**New Request for Advice – Liverpool Hospital Multi-storey Carpark
(SSD-10388) (Liverpool City)**

TAB A – TfNSW Comments – SSD 10388 EIS Liverpool Hospital Multi-storey Carpark

PROJECT NO.	DRAWING NO.	ISSUE
21807	A-SSDA-MSCP-05	06
STATUS	FOR REVIEW

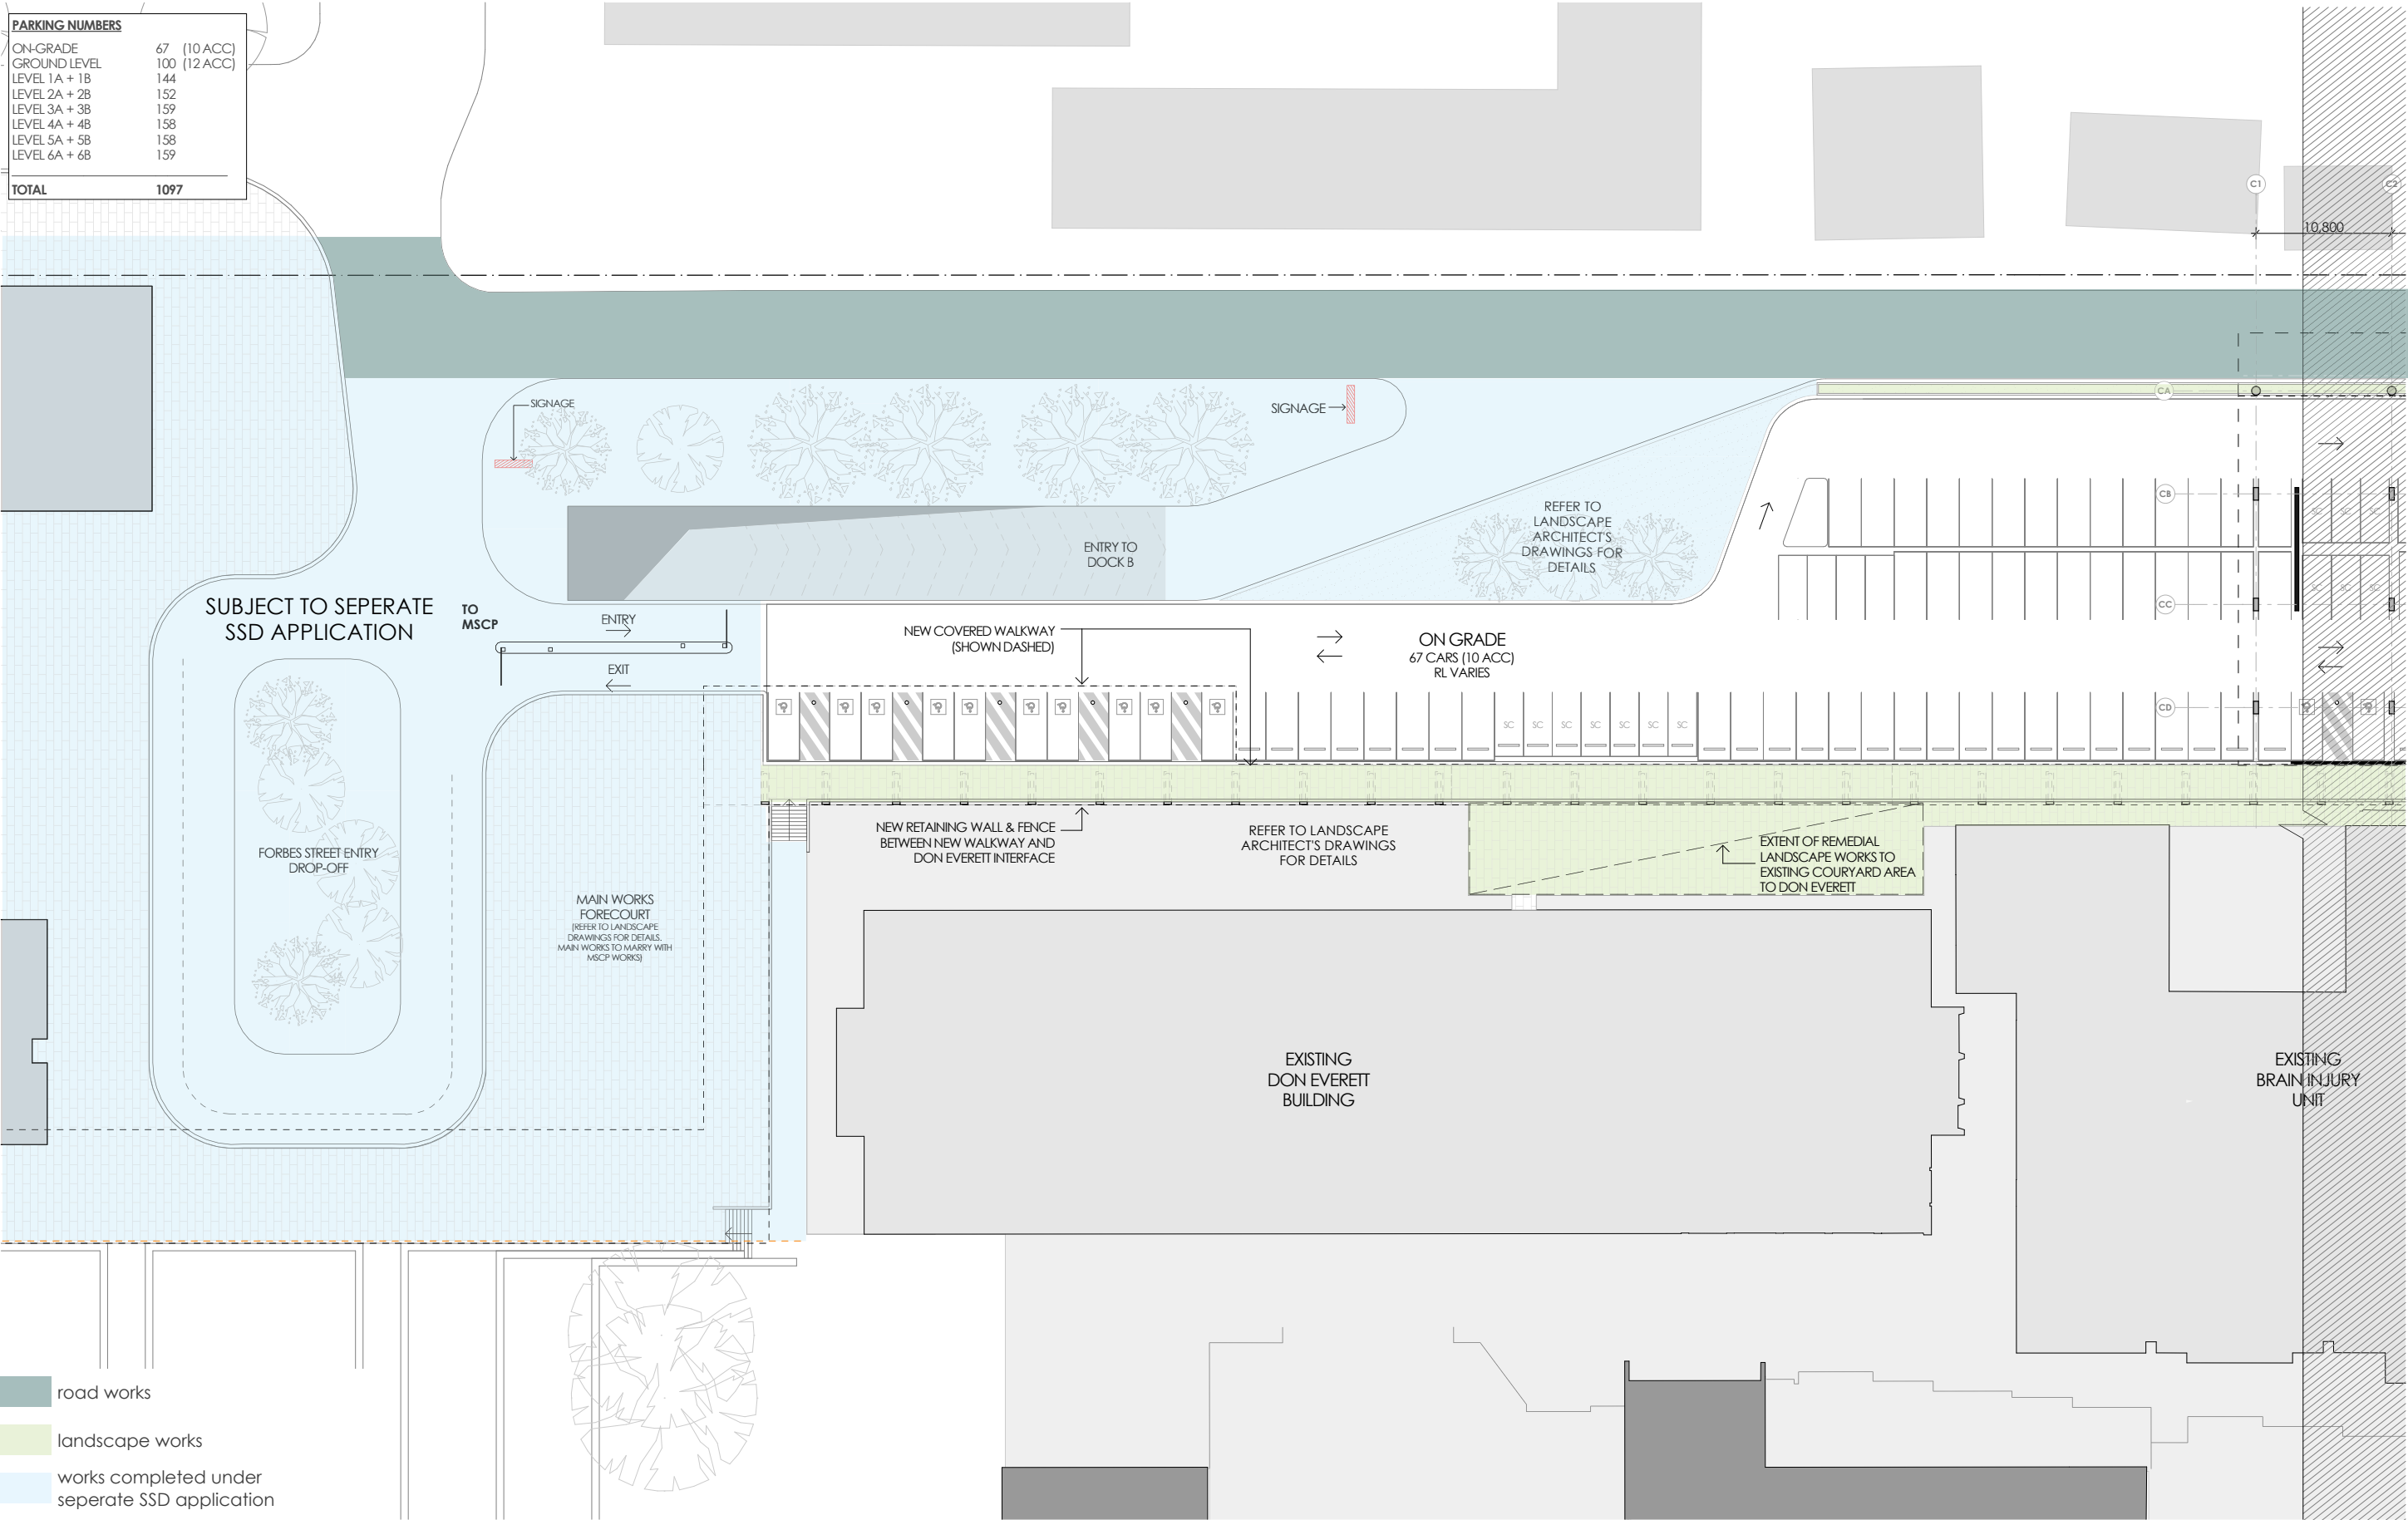
The 33 accessible car parking spaces in the traffic report is calculated based on the Liverpool DCP requirement and the capacity of the new car park. This does not cater for the overall demand of accessible parking spaces across the whole hospital.

It is requested that the applicant review the needs for accessible parking across the whole site and if appropriate explore opportunities increase the number of accessible parking spaces in the new car park.
